Re: Thorp Landing Plat, LP-23-00001

Response to Comments Matrix

EXHIBIT A TO COMMENT RESPONSE MATRIX RE THORP LANDING

Drawing file: LP-23-00001 Thorp Landing / LP-23-00001 Thorp Landing Preliminary Plat Map Updated 1-25-23.pdf

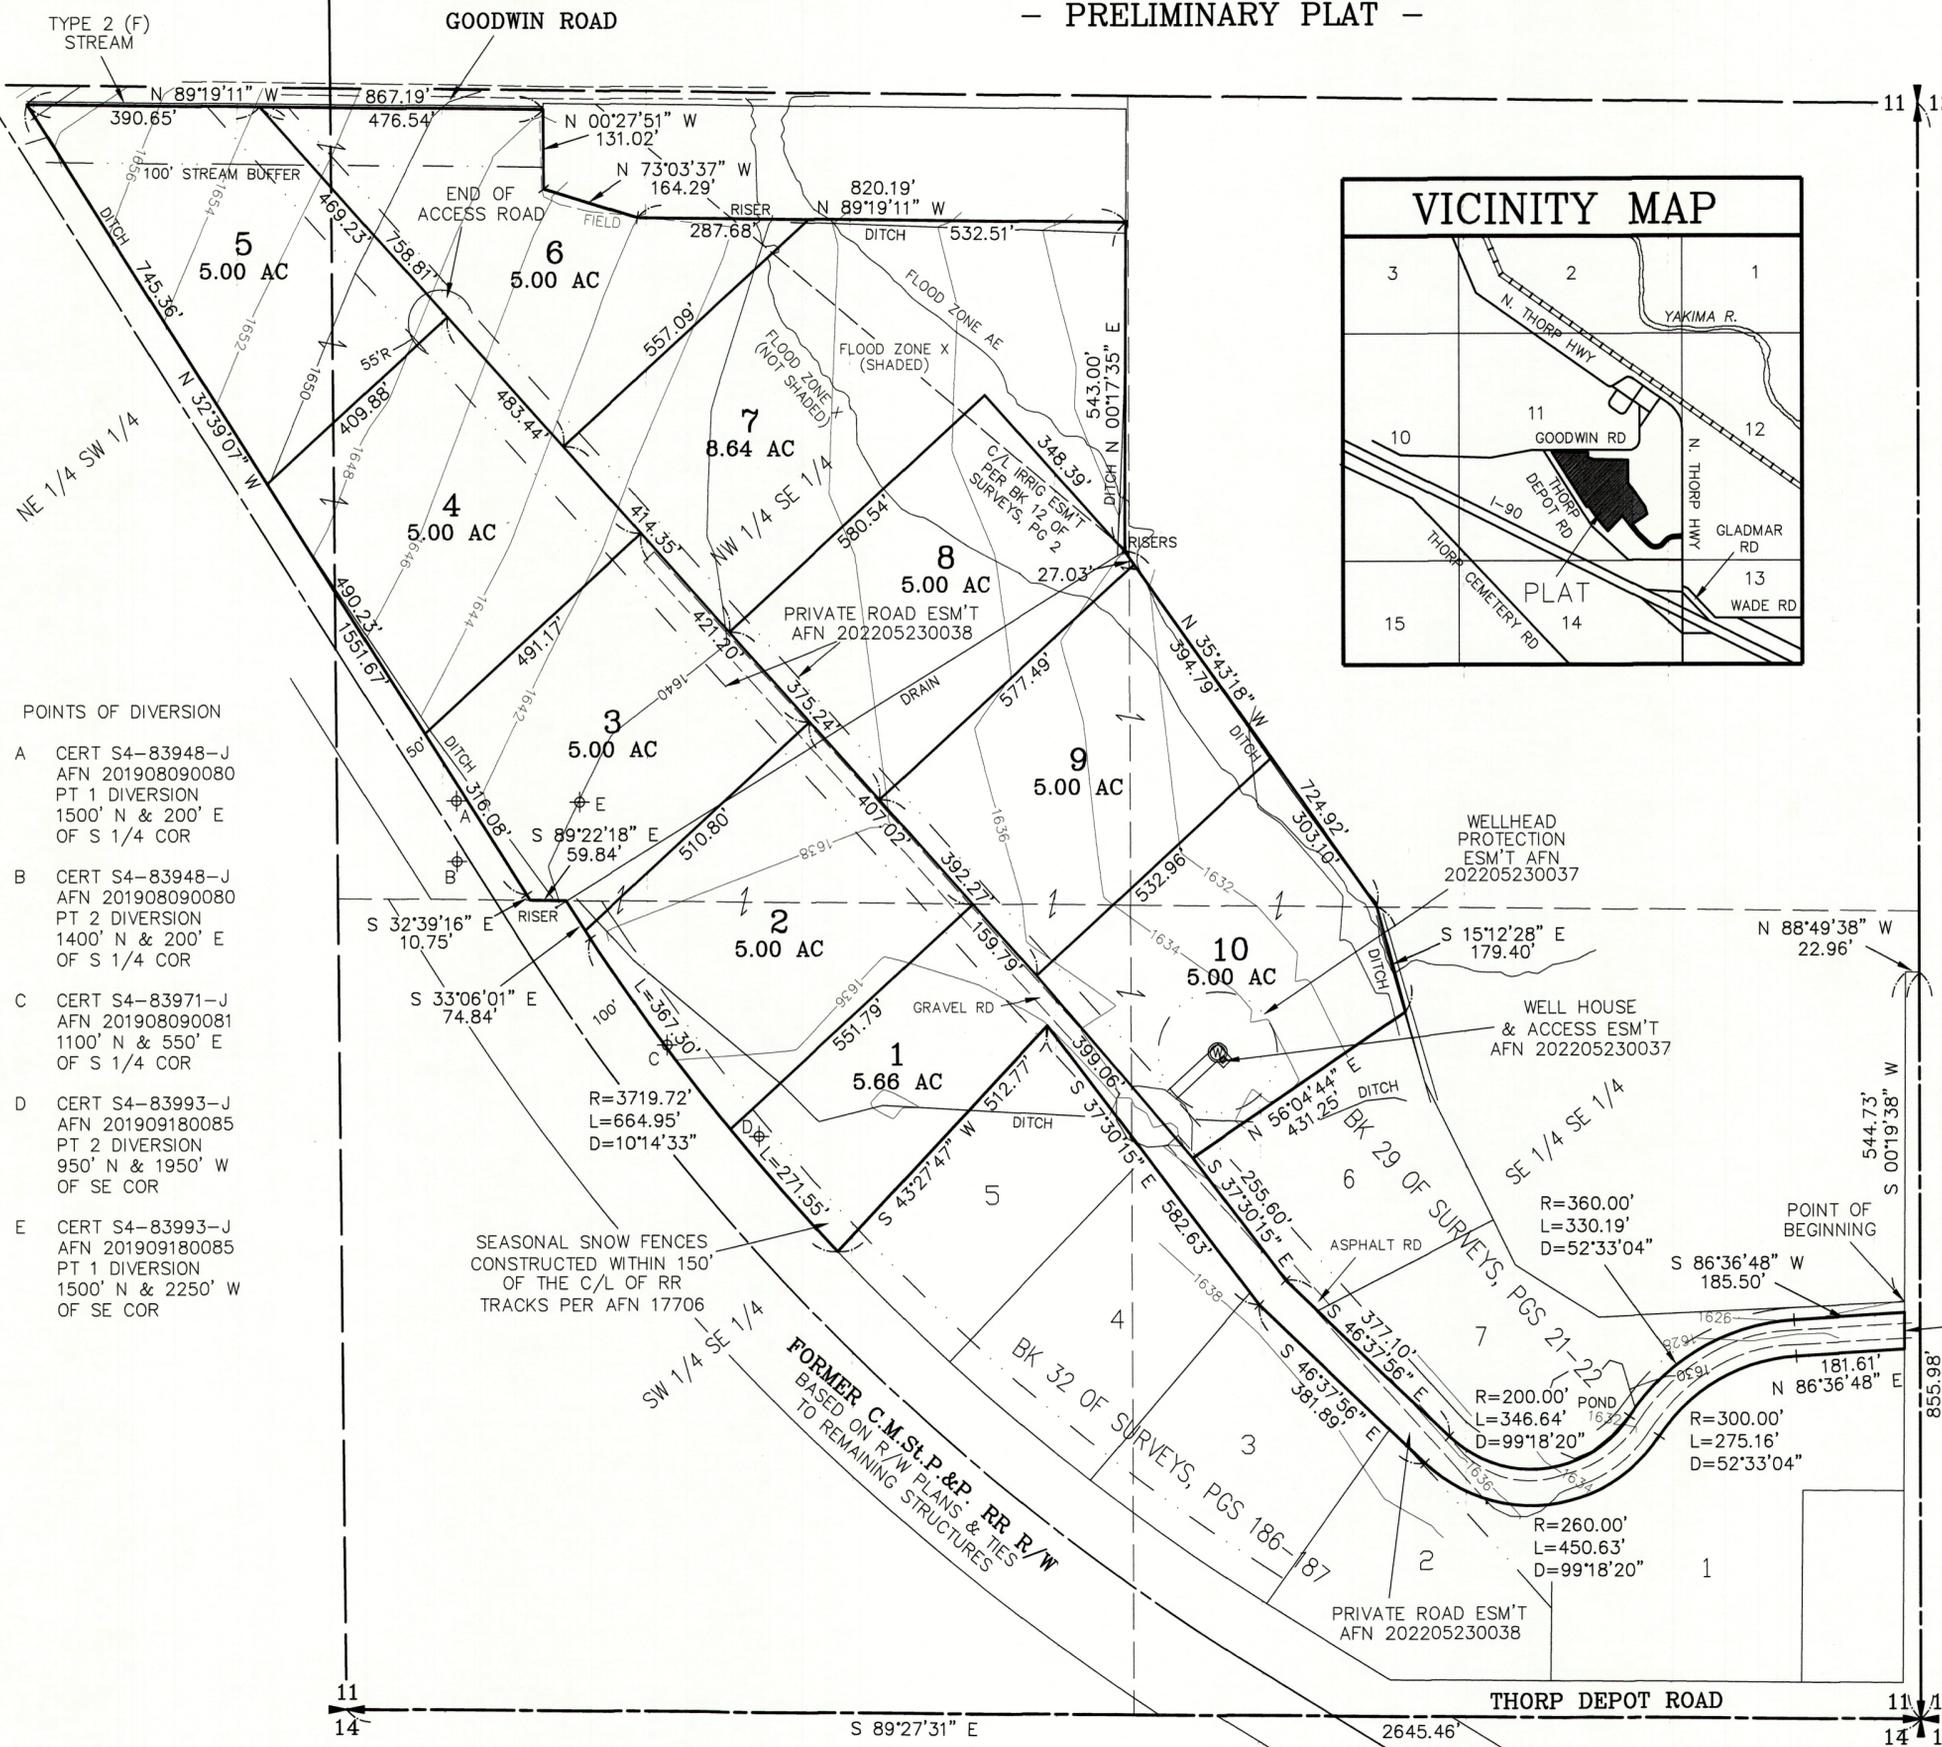
4. Roads longer than 150' in length are required to provide a fire apparatus road turnaround meeting the requirements of Appendix D in the International Fire Code.	Agreed. The preliminary plat map reflects the location of the turnaround.
